In respect of
Wells Farm, Northaw Road East, Cuffley
(LPA Ref: 6/2020/3451/MAJ)

Technical Note in Response to Hertfordshire County Council
Consultation Response on Transport Matters
(HCC Ref: WH/5158/2021)

- 1.6 This Technical Note (1911-066/TN/01, March 2021) has been prepared in response to the matters raised by HCC in their consultation response and is intended to provide a comprehensive submission of information following various email exchanges on technical matters between TPA and HCC.

TITLE:
**Proposed Site Access
and Visibility Splay
(2.4m x 160m)**

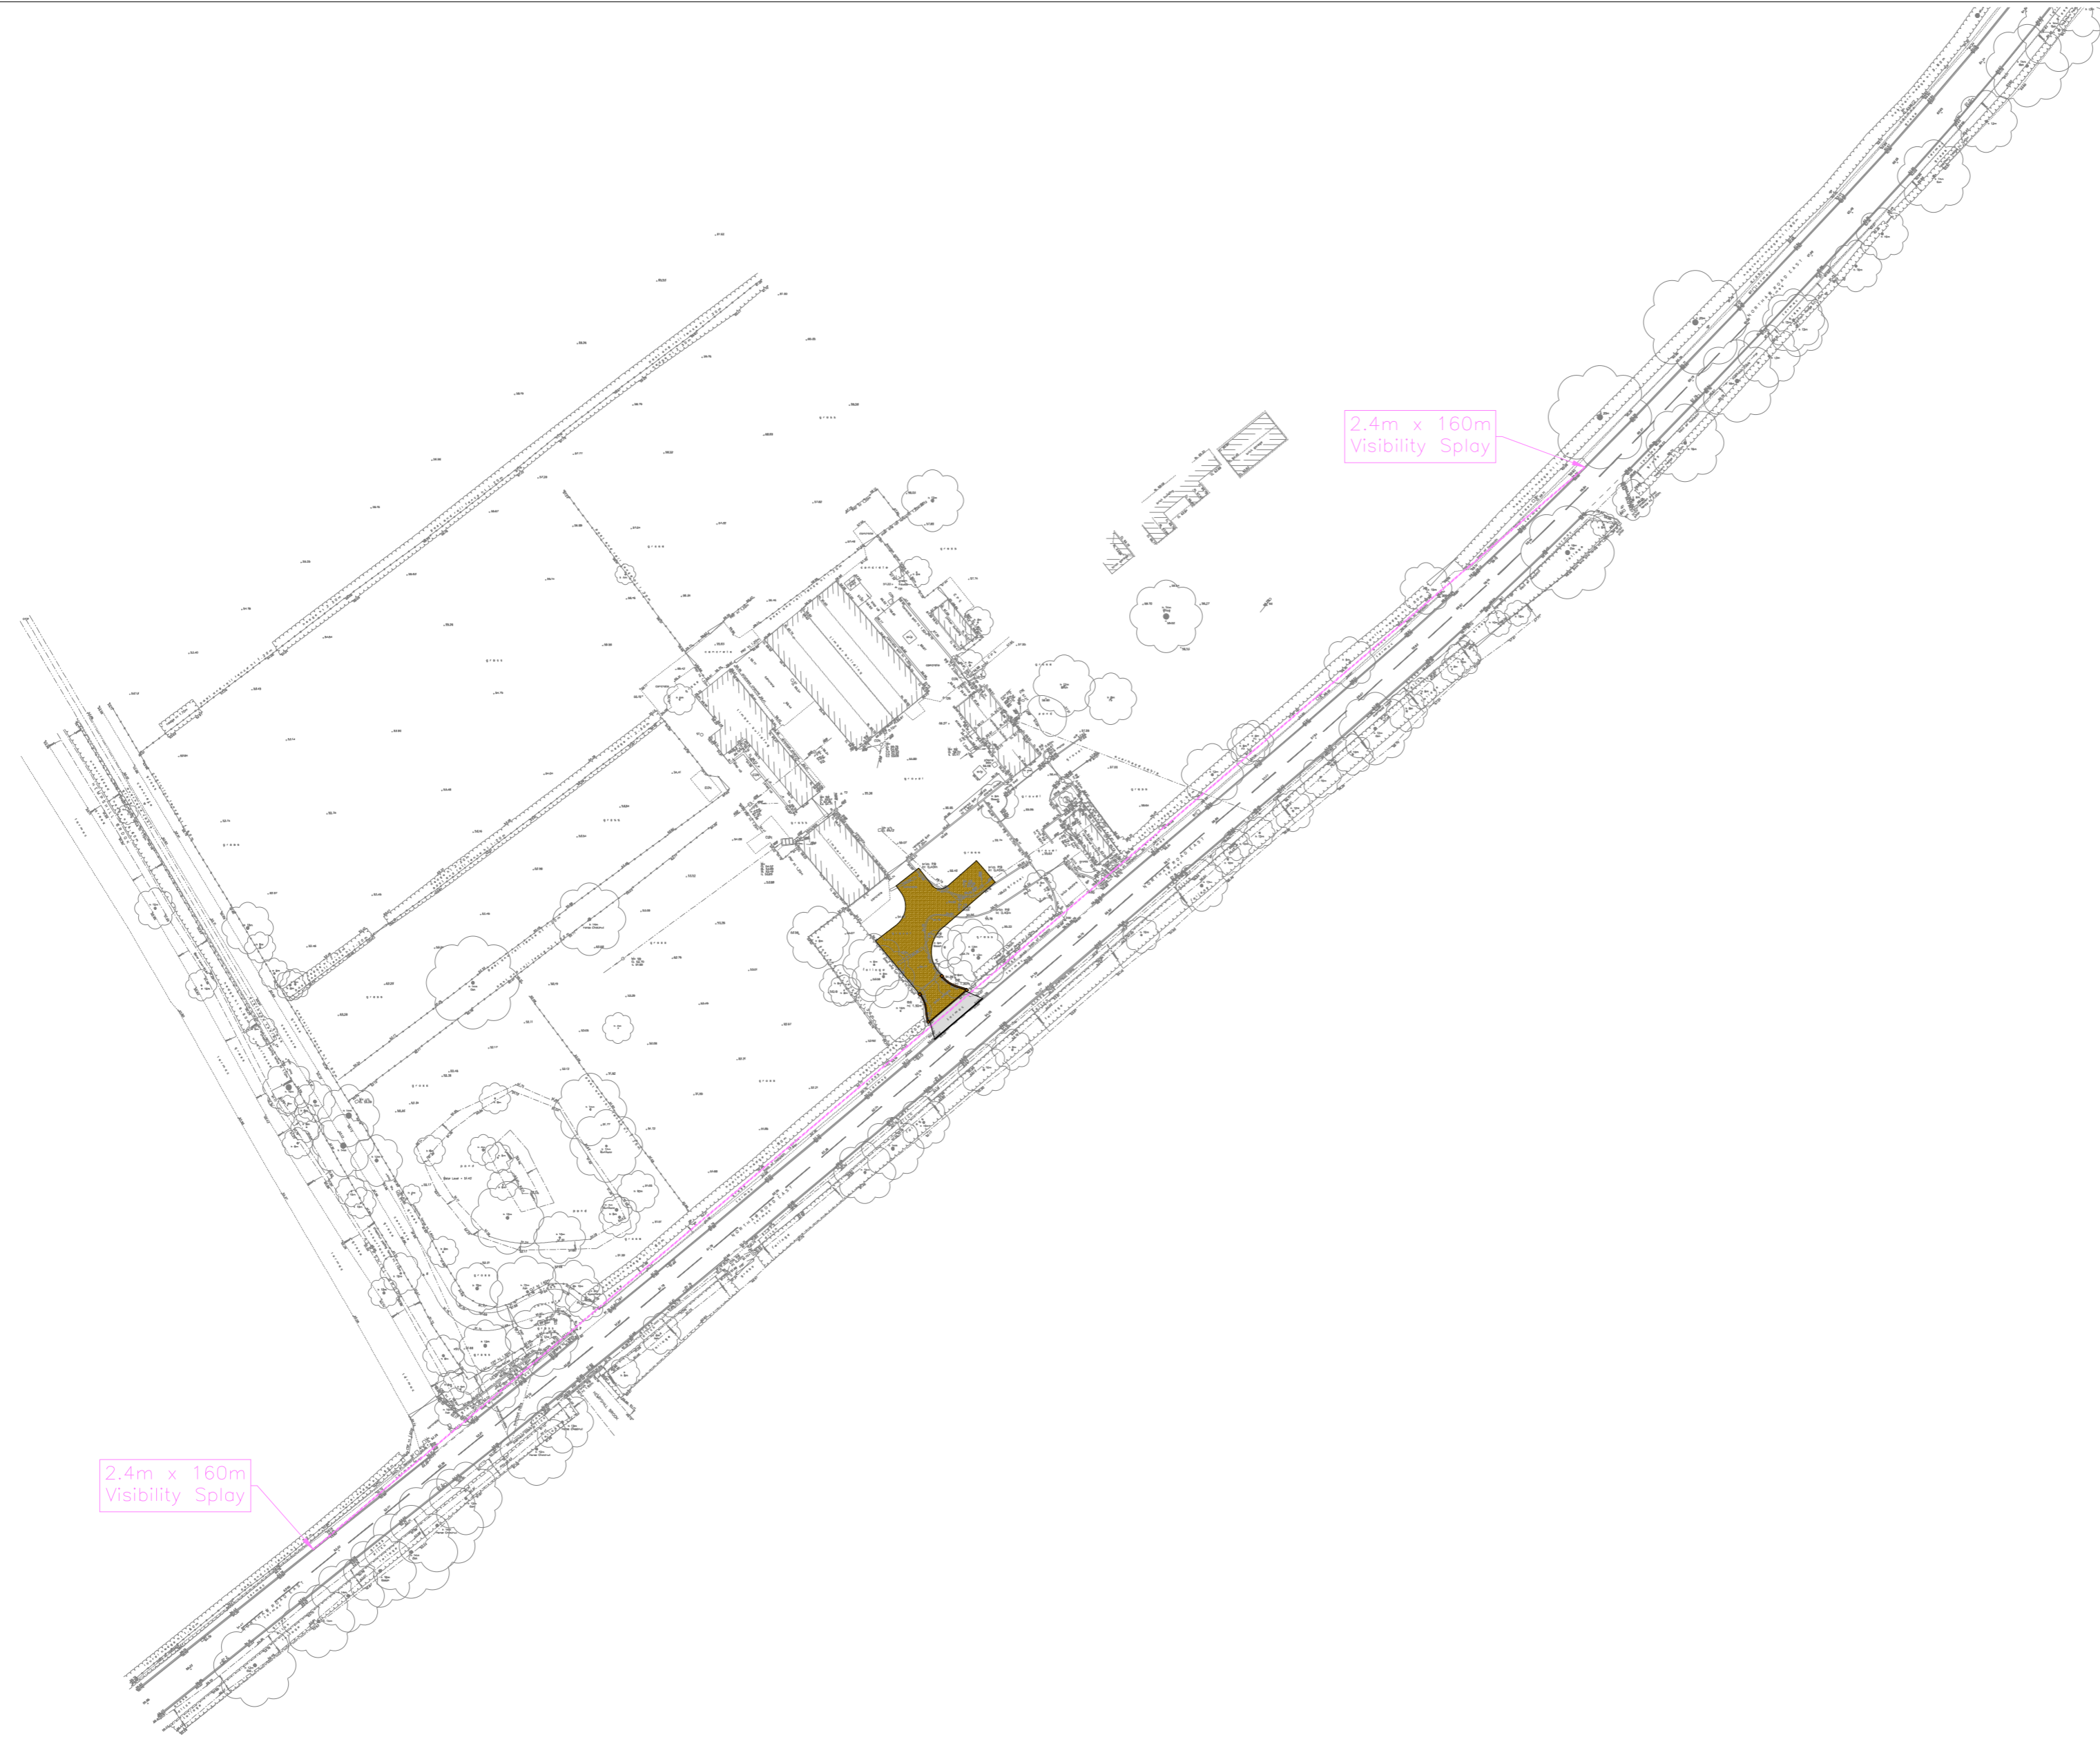
- It is evident the required visibility splays at the site access cannot be achieved with the proposed reduction in speed limit from national speed limit to 30mph. The details submitted to support the reduction in speed limit are currently insufficient. The applicant must be aware of the required characteristics for a 30mph zone set out in the HCC Speed Management Strategy (November 2020)”.*

Vehicular Access	A visibility splay drawing (Drawing No. PL03) has been submitted for the access which shows visibility of 2.4m x 160m, which is not considered suitable for national speed limit or the standards contained in the DMRB/Road in Hertfordshire: Highways Design Guide.	TPA dispute that a 2.4m by 160m visibility splay is not suitable at this location and further details in relation to this are provide within Section 3.
Speed Gateway	In order to provide acceptable visibility splays at the access, a change of speed limit has been proposed.	TPA do not agree that a change of speed limit is required to provide acceptable visibility splays. The Speed Gateway was a suggested as part of the suggested potential 'Wider Improvement'. Further details of this are again provided in Section3.
Internal Highways	The applicant should be aware the internal highways at the site will remain private and the Highway Authority will not seek adoption.	This point is noted and as envisaged by the applicant.

- 3.2 Further to an email exchange with HCC it is understood that their approach to speed limits in non-urban locations is no stepped reduction and the use of 'desirable minimum' stopping site distances, which in this instance would be 215m.

- 3.3 It is further understood that the Road Safety Audit team and the wider HCC Highways team will generally only consider a reduction from the 'desirable minimum' if 85th percentile speeds from a speed survey support such a proposal. On this matter it has been confirmed "In terms of the visibility splays, based on the 85th percentile survey results it is recommended you interpolate between the 'desirable minimum' sight stops distances shown in Table 2.10 of CD109. Evidence provided by yourself (i.e. the speed survey results) can then be subject to professional judgement regarding any use of the use of 'one step below'".

- 3.7 On the assumption that the 85th percentile speed represents the design speed then interpolation of 'desirable minimum' stopping site distances in Table 2.10 of CD109 indicates that the stopping sight distance for 47mph is 138m. On this basis it is felt that the speed survey justifies the selection of a 160m visibility splay.
- 3.8 For ease of reference a revised version of the Proposed Site Access and Visibility Splay drawing (1911-066.PL03C) is provided at Appendix C, noting the revision is due to the removal of the speed gateway from the drawing.

- 4.2 Swept path analysis of the site access confirms the adequacy of the design and this has been communicated previously to TPA by HCC.
- 4.3 Evidence provide within this technical note confirms acceptability of the proposed 2.4m by 160m visibility splays at the site access junction, on the basis recorded speed data suggest a stopping sight distsnce of 138m.
